## Response to Submissions Report

State Significant Development – SSD 17\_8365

Penshurst Public School Redevelopment

510 Forest Road, Penshurst

DRAWING NAME
FLOOR PLAN - LEVEL 0 - PART 1

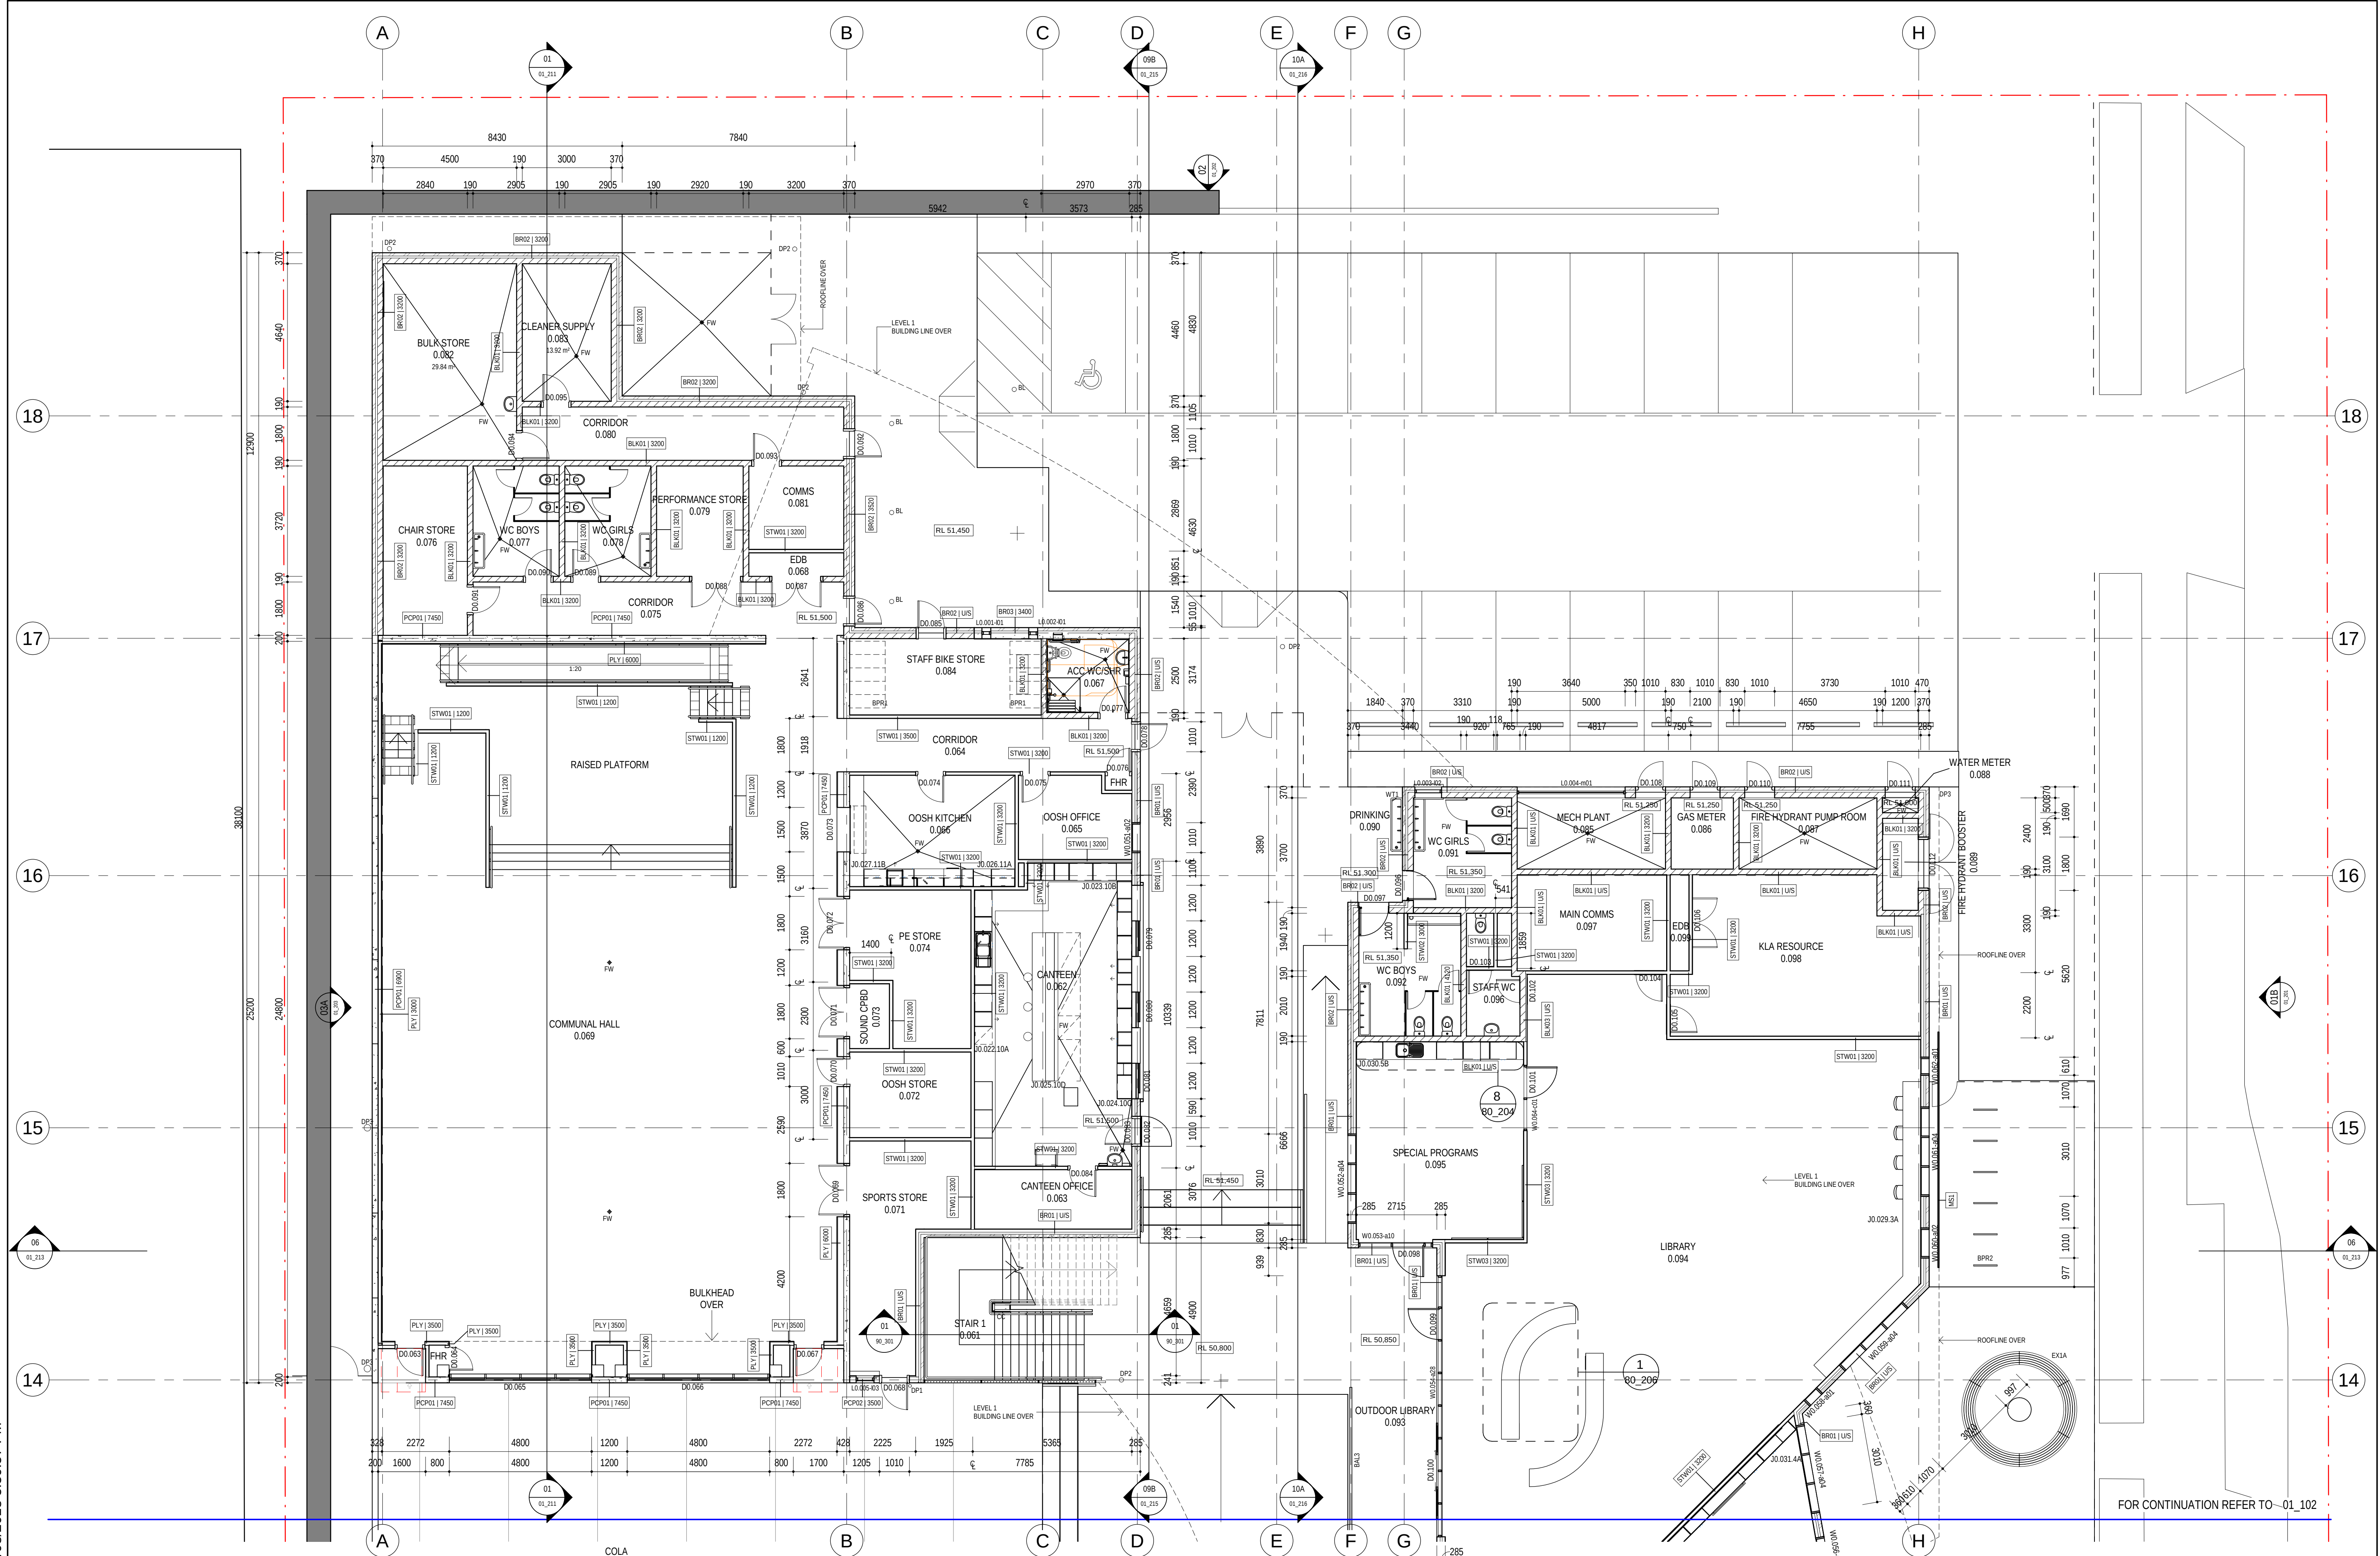
| Issue                                                                                                                                                                                                                                                                                                                      | Response                                                                                                                                                                                                                                                                                                                                                                                        | Reference                                                                                            |
|----------------------------------------------------------------------------------------------------------------------------------------------------------------------------------------------------------------------------------------------------------------------------------------------------------------------------|-------------------------------------------------------------------------------------------------------------------------------------------------------------------------------------------------------------------------------------------------------------------------------------------------------------------------------------------------------------------------------------------------|------------------------------------------------------------------------------------------------------|
| <ul style="list-style-type: none"> <li>Provision of bike parking facilities for students and staff as well as end of trip facilities where possible</li> </ul>                                                                                                                                                             | Bicycle parking for students is provided at the frontage of the site to Arcadia Street, as shown on the Site Plan Ref: DA_00_004, while staff bicycle storage and end of trip facilities are shown on the Floor Plan Ref: DA_01_010.                                                                                                                                                            | N/A                                                                                                  |
